DESIGN STATEMENT BY THE CONSULTANT

PROJECT: Trinity Grammar School Renewal Project
Prospect Road, Summer Hill, NSW, 2130

Arcadia is responding specifically to the RFI received from DPIE relating to proposed modifications to the Landscape SSDA package

Trinity Grammar School Redevelopment – Modification 2 (SSD-10371-Mod-2)

Source: Arcadia Landscape Architecture, Drawing No. 200, February 2022, Issue F.

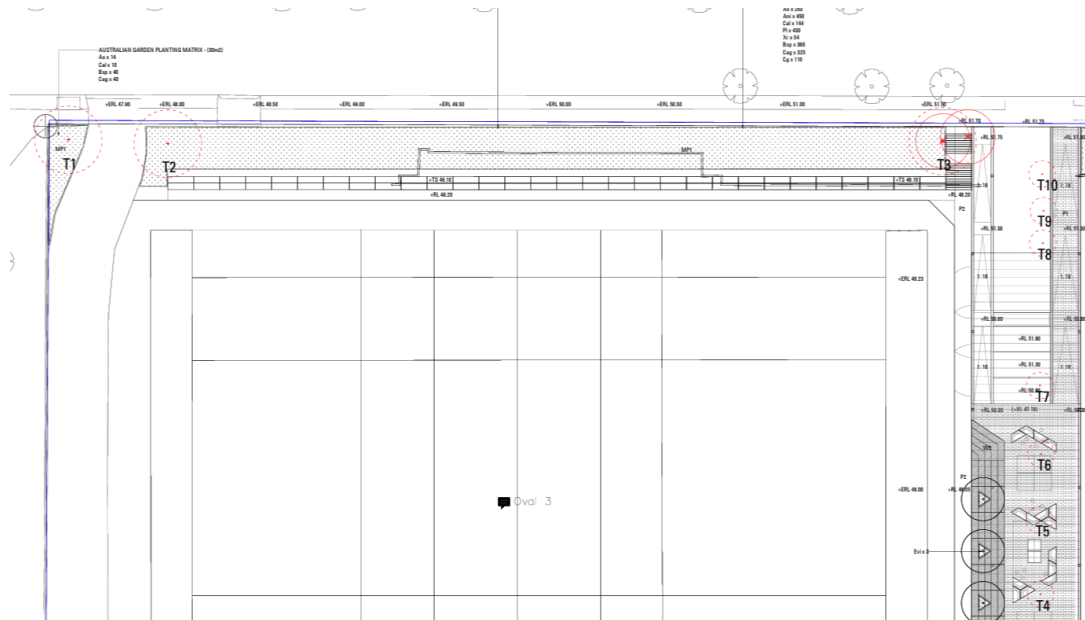
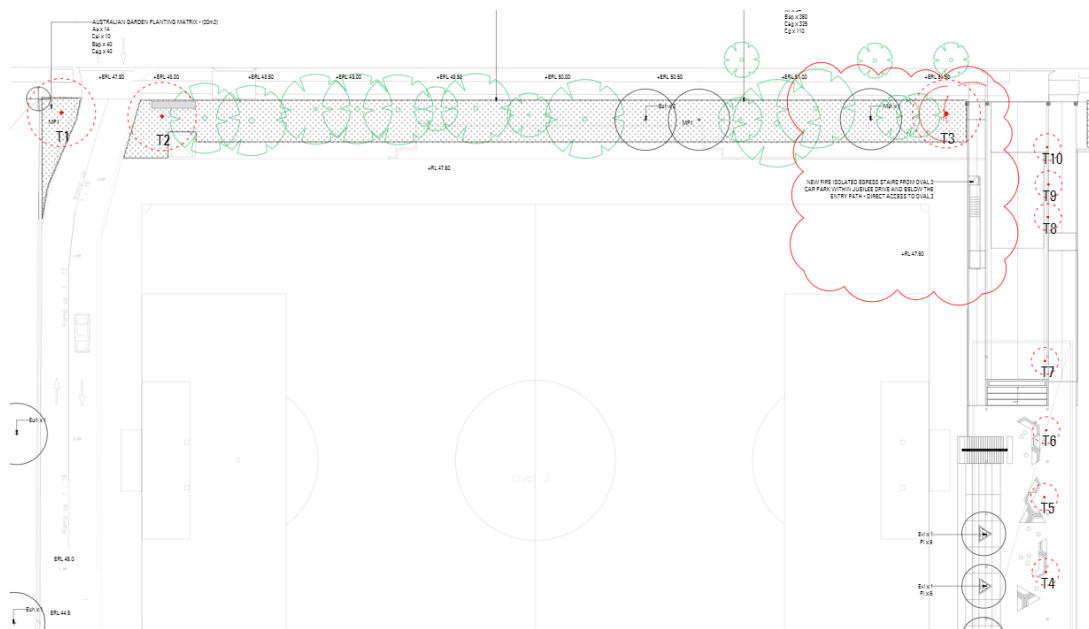
2(b) The Landscape Master Plan (sheet 100) does not accurately detail the location of trees at Lot 7020 DP 93165, when compared to the Landscape Plan Sheet 200.

The amended landscape masterplan sheet 100, revision G, provides better legibility of the site boundary and location of the trees within Lot 7020 DP93165 (Yeo Park), consistent with what is shown on landscape sheet 200. We have created a new sheet 101 Index Plan and removed the sheet extents from sheet 00 Landscape Master Plan so as not to obscure the tree planting to Lot 7020 DP93165 (Yeo Park).

Source: Arcadia Landscape Architecture, Drawing No. 207, February 2022, Issue F.

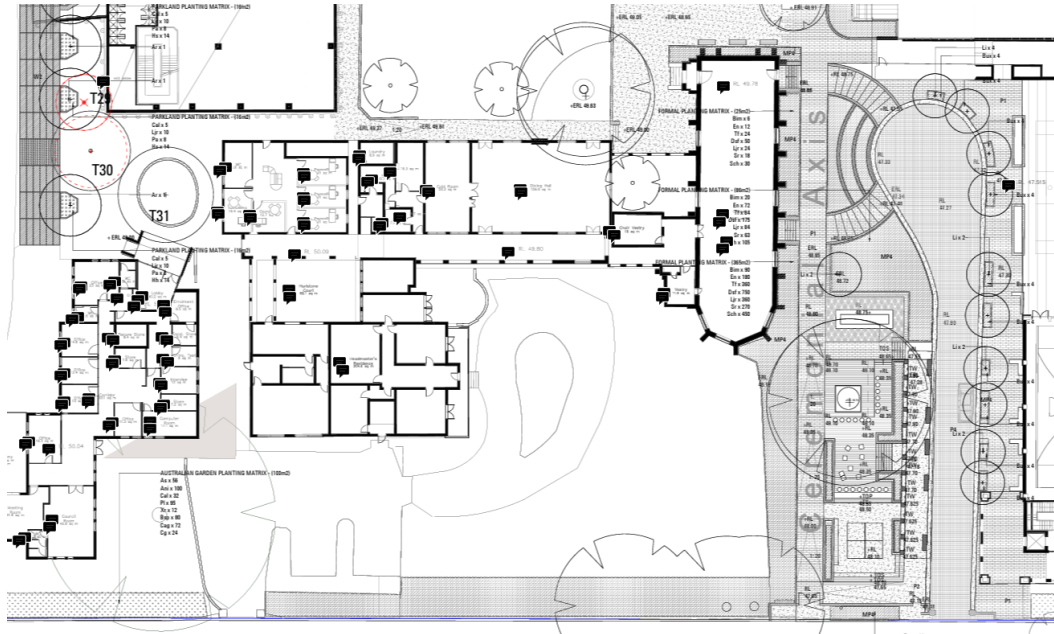
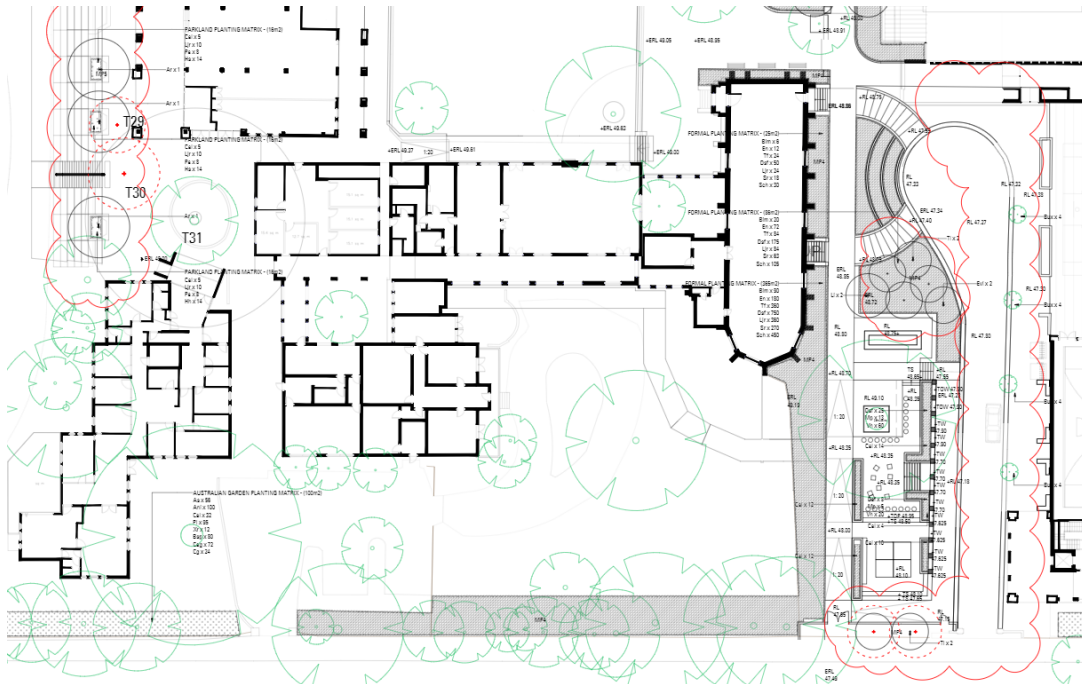
2(h) The Landscape Plan (sheet 207) identifies that the four Japanese Box trees are proposed to be removed, under this modification application. This is conflicting with the approved deferred commencement plans, as these four trees were shown to be retained. The annotation on the plans submitted on 25 March 2022, being "out of scope of development", provides unclear justification as to why these trees are now sought to be removed. The Department considers that these trees should be retained. You are requested to amend the plans to reflect this. Additionally, the submitted arborist report, only comments on the possible removal of the two trees at the Prospect Road frontage. No commentary on the four Japanese Box trees has been made in the arborist report. The Arborist Report should also be amended accordingly.

The amended landscape drawing sheet 207, revision G, demonstrates that the 4no. existing trees to the northern side of Chapel Drive will be retained as there are no longer any proposed landscape works to the northern side of Chapel Drive.

PLANTING SCHEDULE

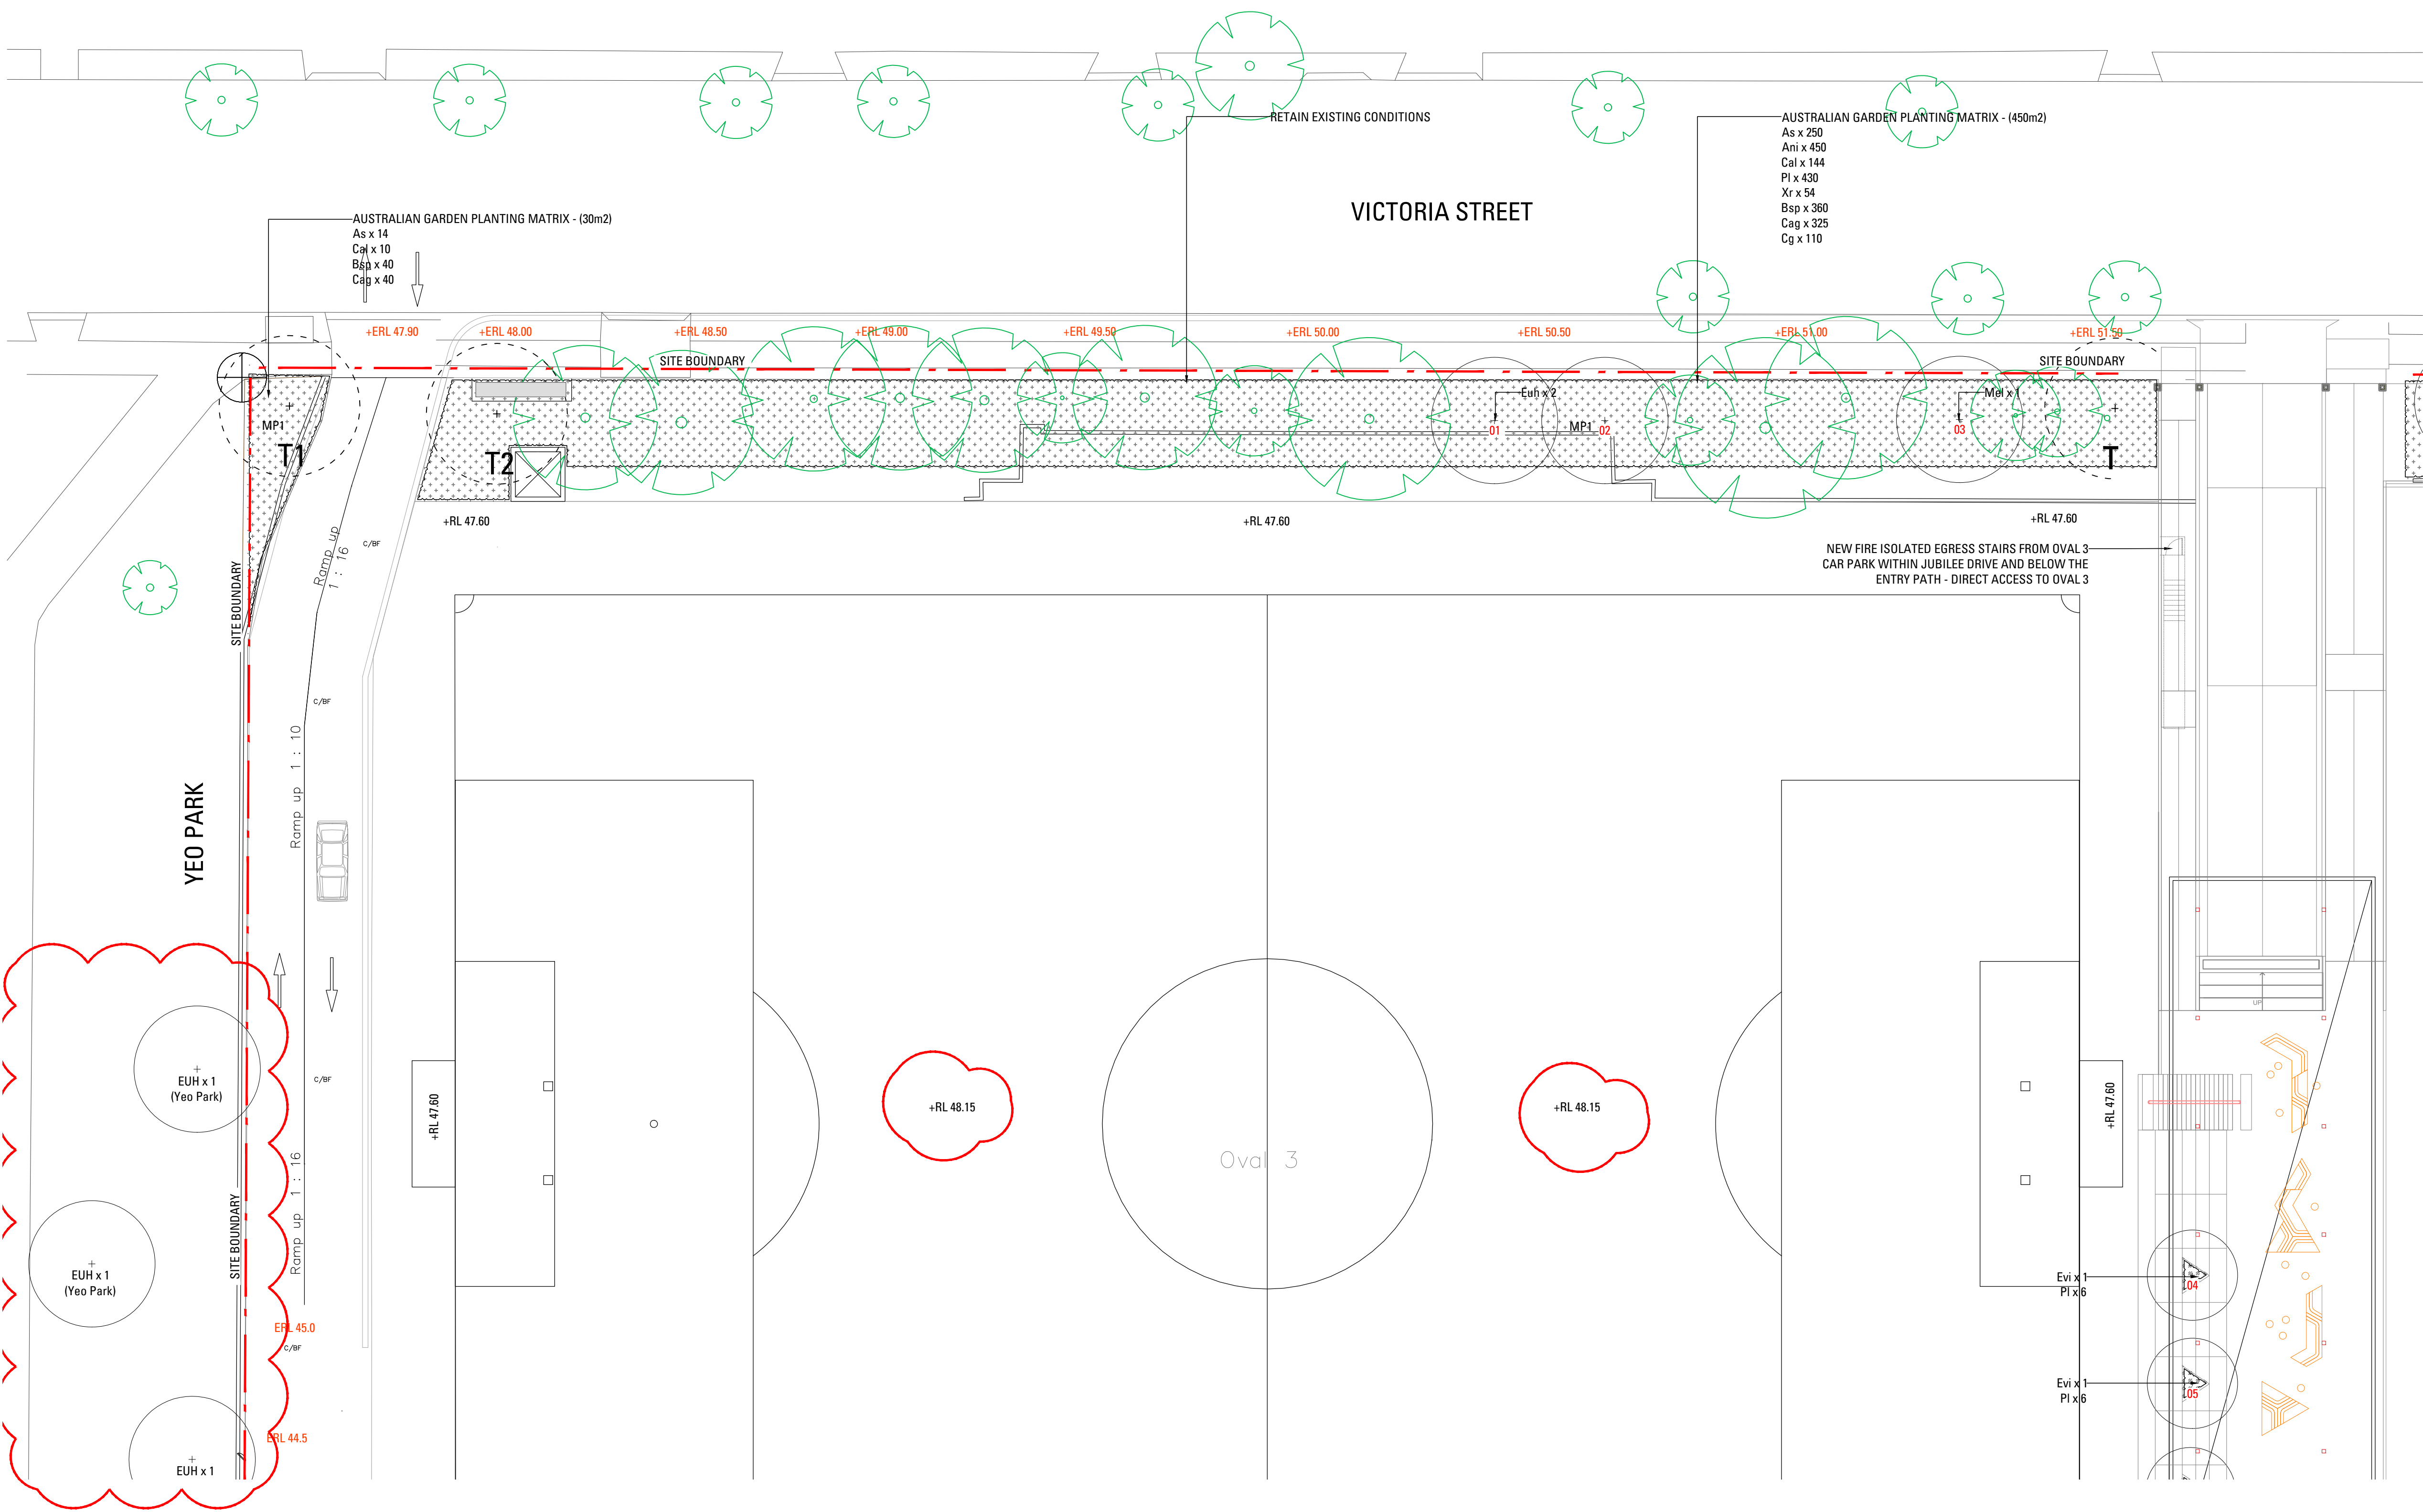
2(d) All proposed trees on the landscape plans should be number identified. The proposed planting schedule table (sheet 100) should include the tree identification numbers

The amended landscape plans and planting schedule, revision G, have provided number identification of the 68 new trees proposed within the site. This is to demonstrate compliance with consent condition A1(2)(iii) 'provide for the planting of 67 additional trees consistent with the commitments in the EIS'
